Our ref: 10.121.146

Your ref: SSD 5765

Bowdens Silver Mine (SSD 5765) Environmental Impact Statement

Dams Safety NSW (DSNSW) has reviewed the Environmental Impact Statement for Bowdens Silver Mine (SSD 5765) and has the following comments. The project proposes construction of a Tailings Storage Facility (TSF). It is proposed to construct a dam with a maximum height of 56m. The consequence of dam failure of this structure has been determined as High C (from EIS). It is therefore very likely that this TSF dam will be declared under the Dams Safety Act 2015.

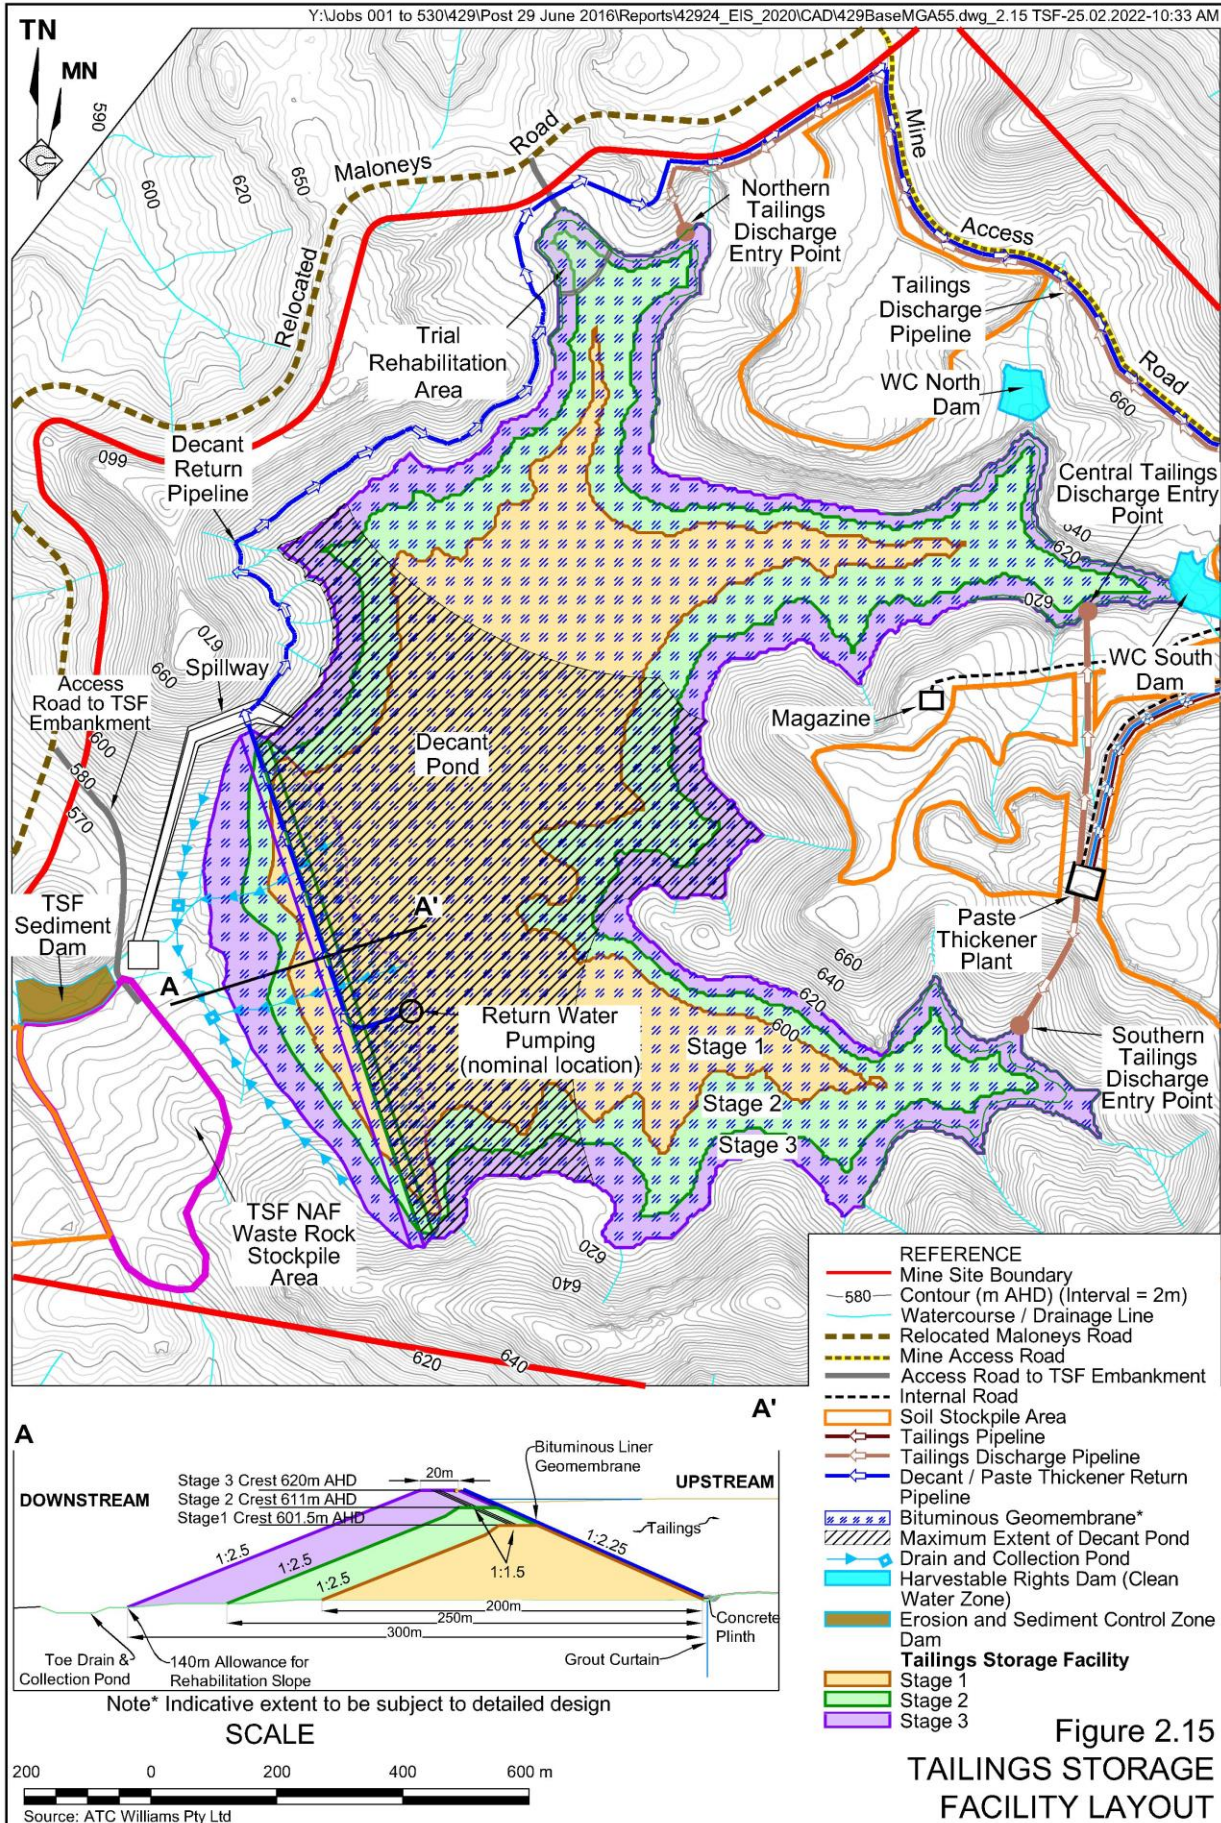
As the consequence of failure of the proposed TSF has been determined as High C (from EIS), the monitoring of the TSF embankment needs to take account of the location of the TSF within an active mine site. It is therefore recommended that:

- Daily inspections of the embankment take place;
- The Company shall ensure that peak particle velocities generated as a result of mining will not exceed 50 mm/s at any point on the TSF Dam embankment. A minimum requirement is that monitoring of blast vibration occurs at the closest point to the blast on the embankment crest;
- If peak particle velocities exceed 50mm/s, then an inspection of the dam by a suitable dams engineer is required;
- The Company shall develop a program of seepage monitoring, and report any occurrence of changes in seepage from the dam which are considered significant;
- The Company shall implement a program of subsidence monitoring, and report any occurrence of unexplained movement of the dam embankment;

- The Company shall develop a program of piezometer monitoring of geotechnical drillholes within the dam embankment and its surrounds and report on any unexplained movement of groundwater levels.
